Permitting and Inspections Department  
Michael A. Russell, MS, Director

**CBL: 033 D017001**  
**Located at: 33 ALDER ST**

**Inspection Violations**

33 Alder Street  
Back of house

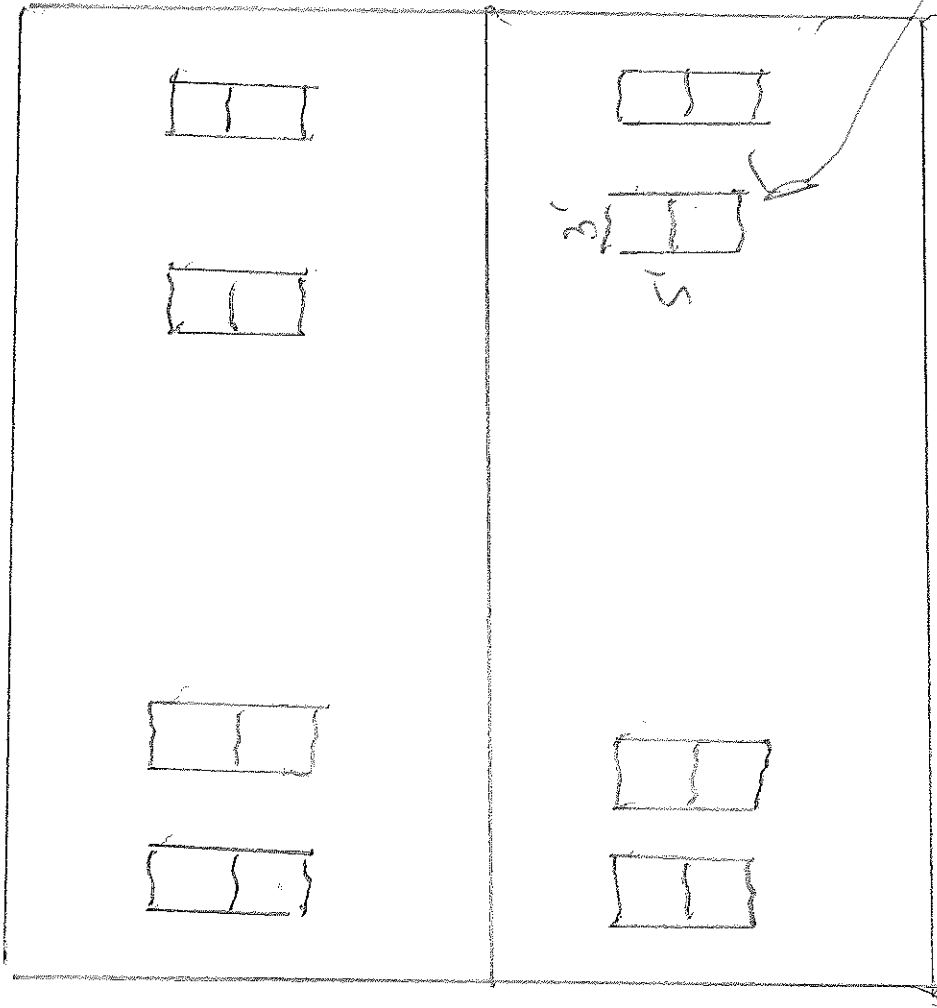
**Notes:** Window for bedroom in unit 2 does not meet egress standards.

**Violation:** NFPA 101- 31.2.1.1 ESCAPE WINDOWS - INSUFF. SIZE; It shall be an outside window or door operable from the inside without the use of tools, keys, or special effort and shall provide a clear opening of not less than 5.7 square feet. The width shall be not less than 20 inches, and the height shall be not less than 24 inches. The bottom of the opening shall not be more than 44 inches above the floor. See NFPA 101 24.2.2.3.3 for a continuation of this code.
